Mrs Julie Bree
Thatched Cottage
Arundel Road
Norton
PO18 0JX

Please ask for: Nicola Moore
Email: nicola.moore@arun.gov.uk
Telephone: Ext 37944
Our Ref: AL/12/21/CLP
Your Ref:
Date: 19th February 2021

Lawful Development Certificate for a Proposed Use or Development

Development: replace existing garden room/outbuilding
Location: Thatched Cottage Arundel Road Norton PO18 0JX

SOUTH SIDE

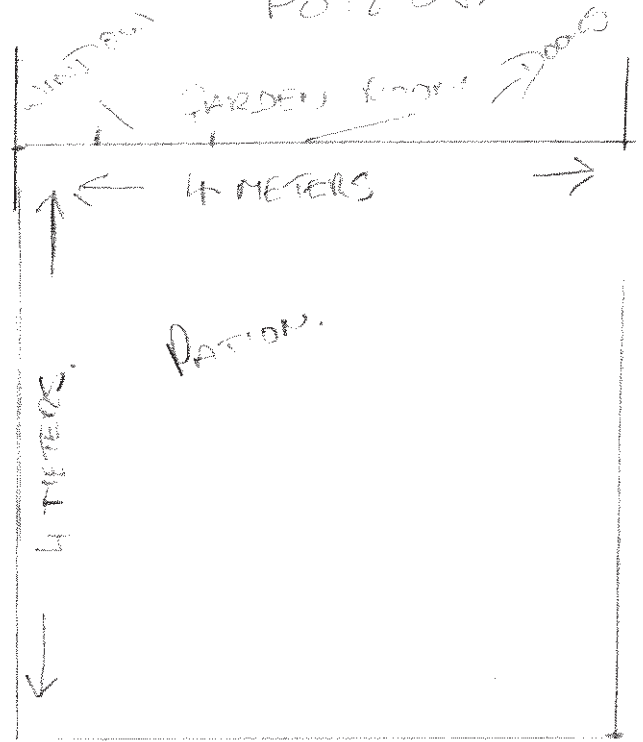
It is not clear if the submitted elevations are existing or proposed. Please clearly label accordingly and resubmit. If they are the Proposed elevations, you must also submit clearly labelled existing elevations. Further details can be found in the Validation Requirements List.
